Subject: 70 Anderson Street Redevelopment
Comment Response Letter

Shukria Wiar – Memorandum to Portland Planning Board 7/18/16

DRAWING NO. **C-10**

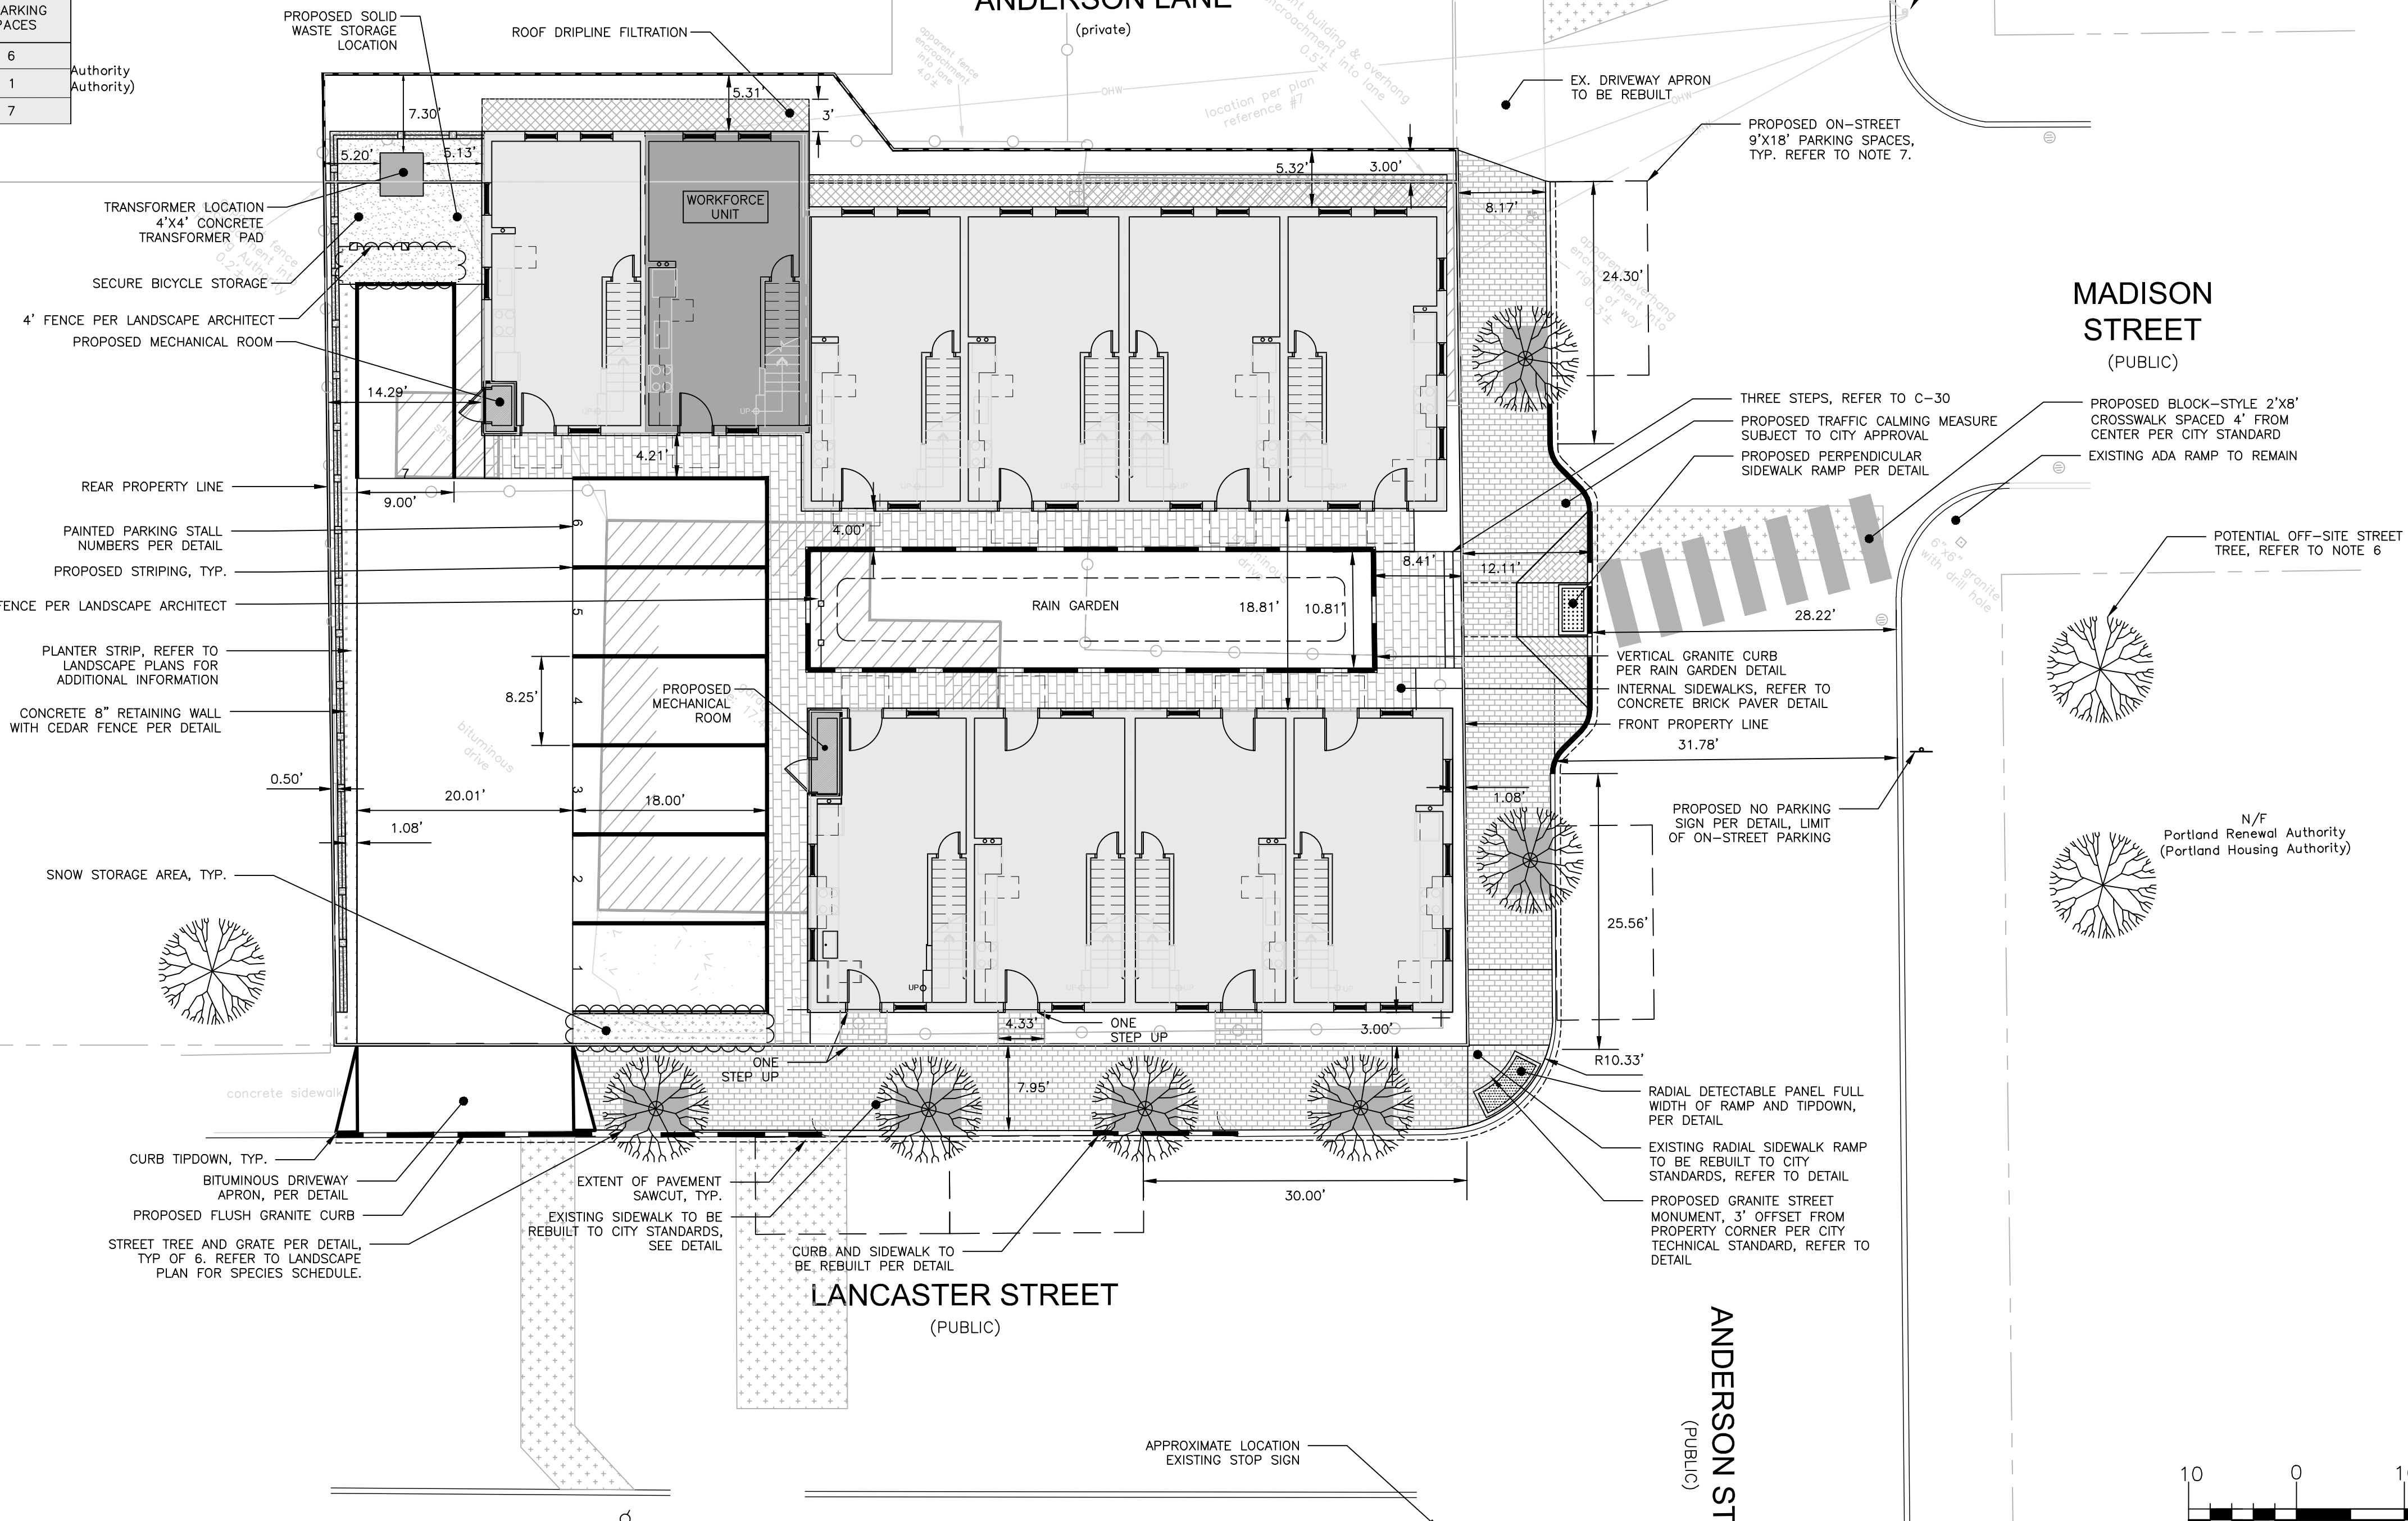
Comment – *The applicant is proposing a transformer and a solid waste storage at the rear of the property that will be visible from the E. Lancaster Street. According to the cover letter, both the solid waste and transformer will be screened; the plans will need to show this as well.*

Comment – *A call-out note for street trees is included on the Site Plan (sheet C-10), but the trees and planters within the sidewalk are not shown.*

Comment – *Pavement trenching/repair in the roadway should be noted on the plan at the locations of the connections to the storm drain.*

Comment -- *G-5 Patios and Plazas: More info needed: Internal patio space design not clear – what are material choices?*

Response – The Site Plan has been revised to show and note a proposed four-foot cedar fence to screen the transformer and solid waste storage area while maintaining access. Based upon continued conversations with CMP we are confident that the surface transformer will not be required; the preferred service would be provided from two transformers mounted to a new CMP pole along East Lancaster Street. Please refer to the Utility Plan for additional information.

Response – Street trees and tree wells per L-1 Landscape Plan have been added to C-10 Site Plan.

Response – Hatches denoting the approximate and estimated extent of utility trenching within Anderson Street for the proposed stormwater outlet has been added to C-10 Site Plan and C-30 Grading & Drainage Plan.

Response – The Site Plan (C-10) has been revised to clarify the internal sidewalk material and is further detailed in C-40, Concrete Brick Paver Profile. The landscape architect has proposed the use of the Genest Katahdin series for its natural stone look and antiqued edge.

DRAWING NO. **C-20**

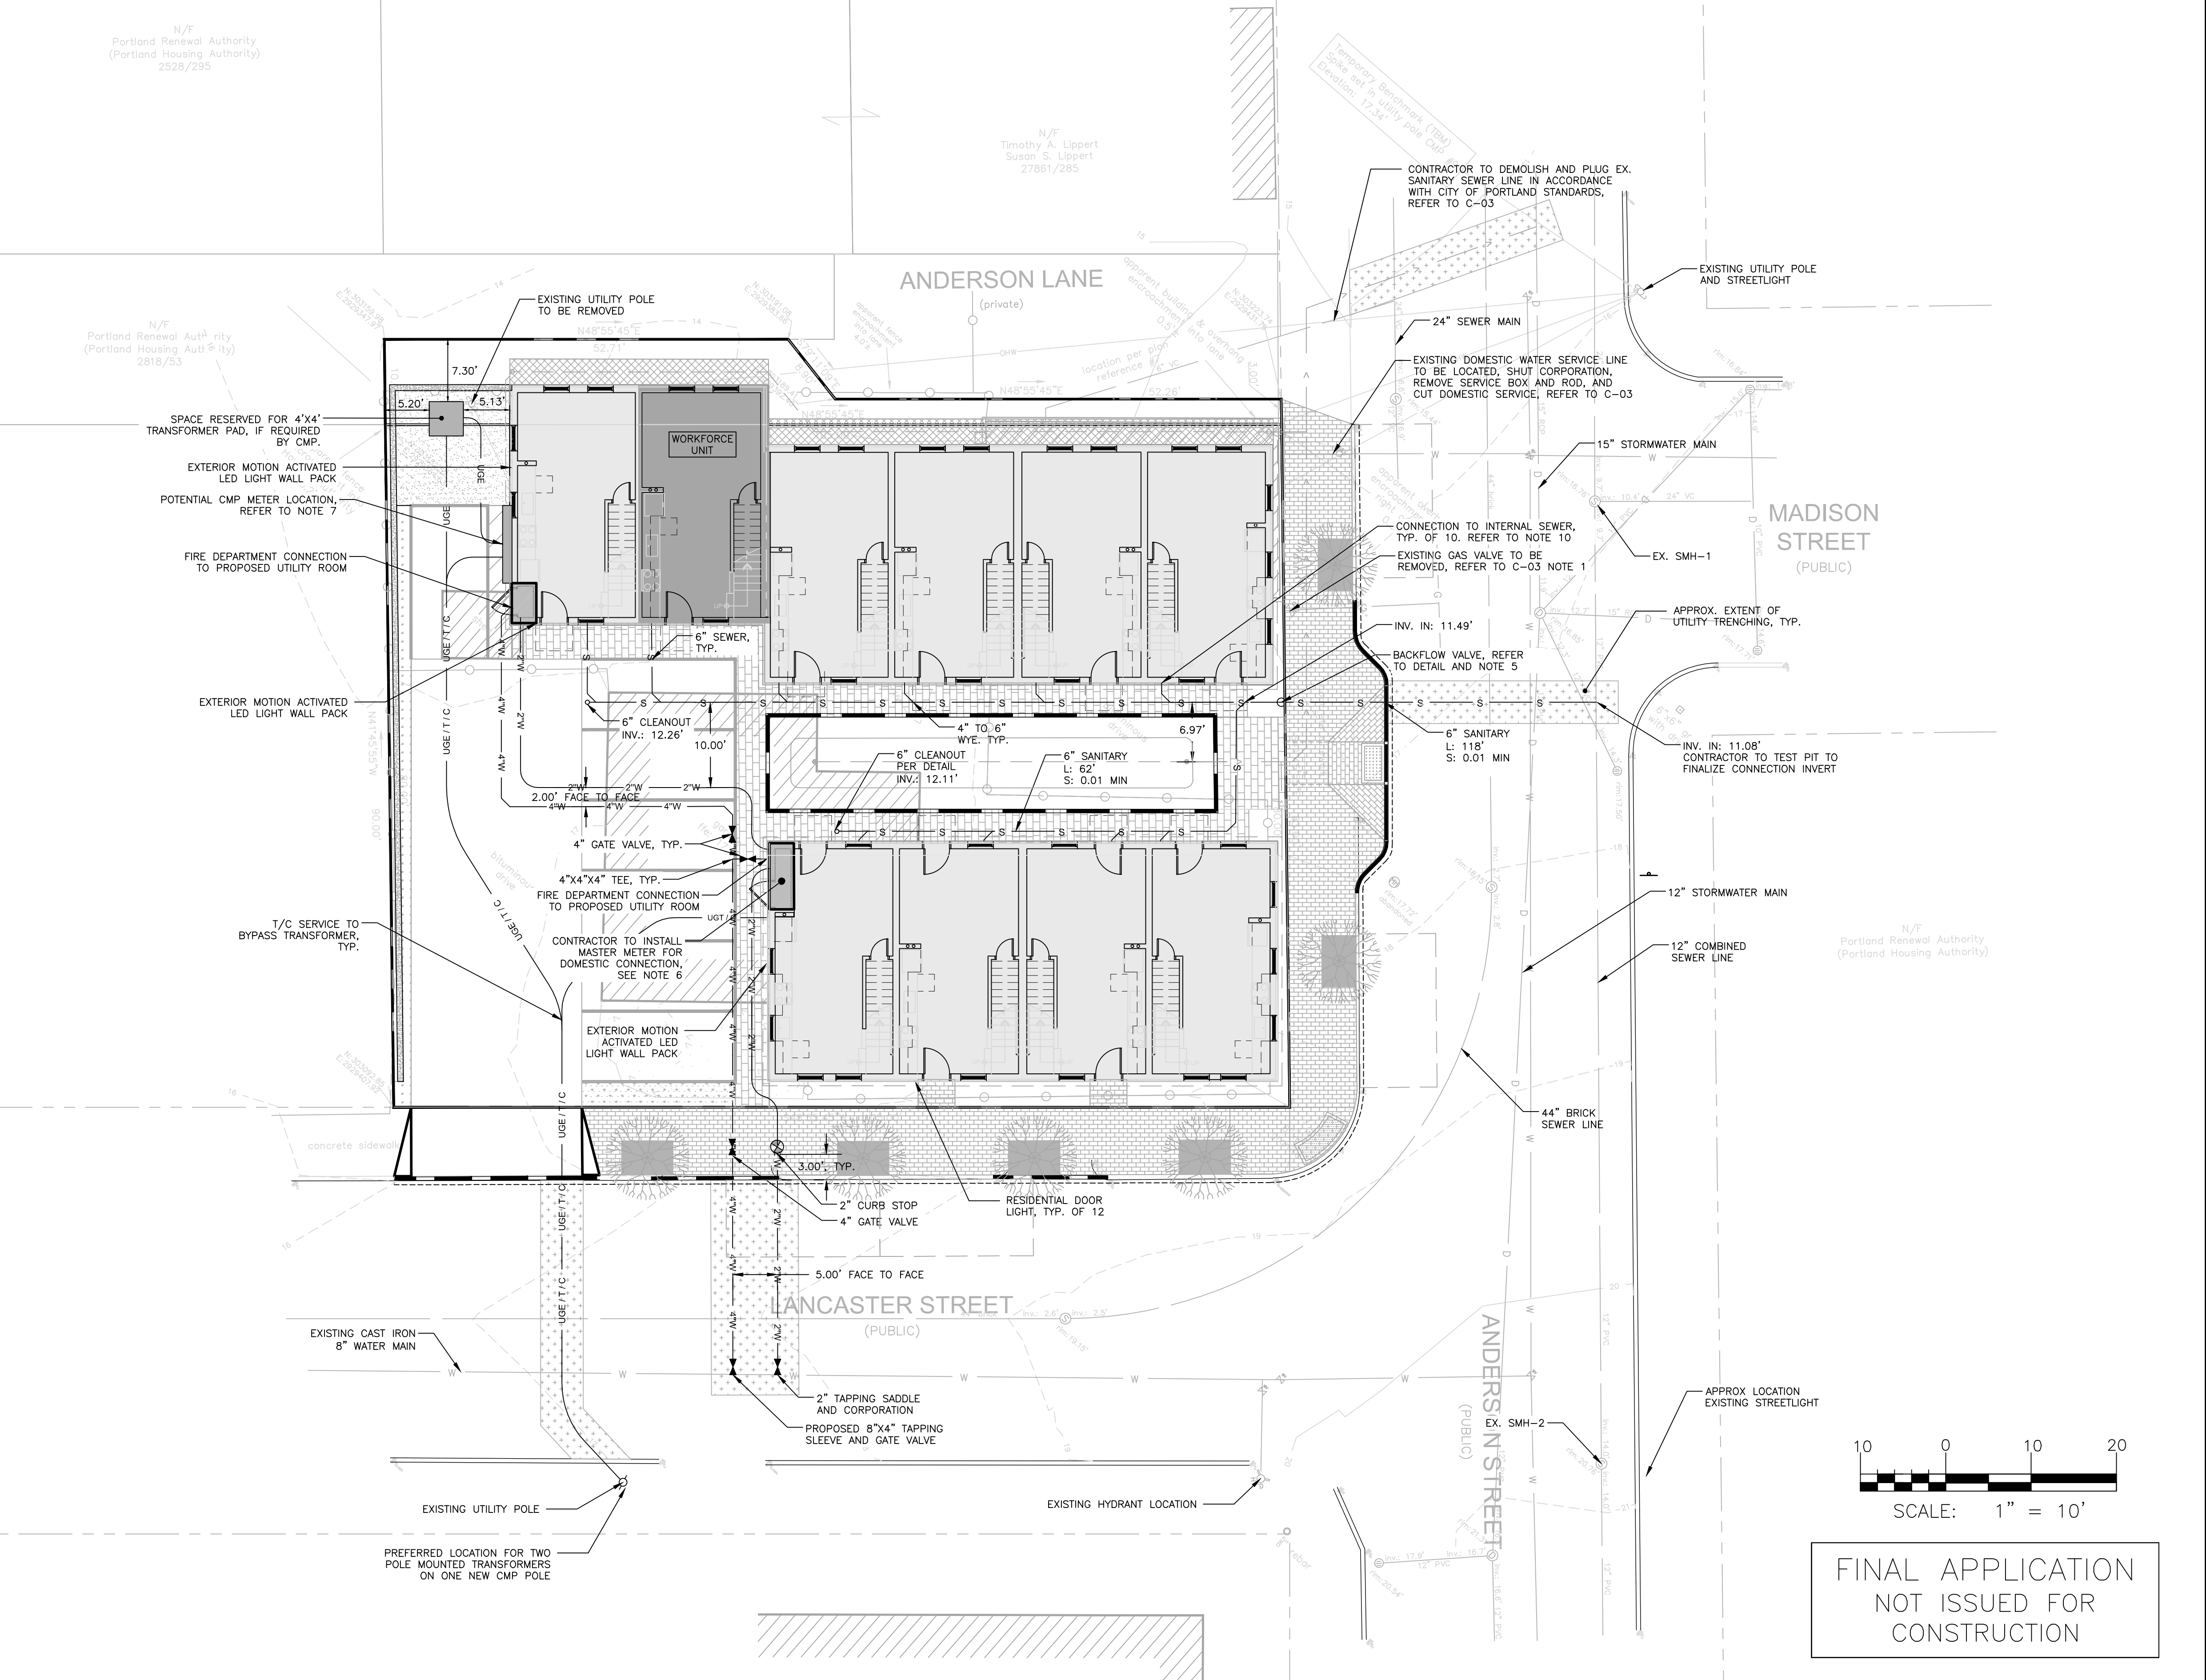
Comment – *The Applicant has noted that there will be an existing sewer lateral abandoned at the site. The Applicant should include a note referencing the City’s technical standards for sewer lateral abandonment. Per Section 2 of the standards, a permit will be required, and the City will need to be notified at the time of demolition so that the Sewer Maintenance Division may assist with the abandonment.*

Comment -- *The rain garden is shown with numerous sewer and water service crossings. The Applicant should verify that these utility pipes will be adequately deep beneath the rain garden system to provide for adequate frost protection. The landscaping plan identifies serviceberry as the trees planted within the raingarden. The Applicant should verify that these plants will not be in conflict with the utility crossings. The pipe trench detail included in the plans notes that no trees should be planted within five feet of a sewer pipe.*

Response – A callout has been added to C-20 Utility Plan noting that the existing sewer lateral is to be abandoned per City of Portland technical standard. The contractor will be responsible for contacting the City at the time of demolition to ensure compliance of the removal process.

Response – The proposed sewer services have been revised to run below the internal brick sidewalks on either side of the rain garden instead of running below it; the proposed individual domestic water service will now be routed below each building slab.
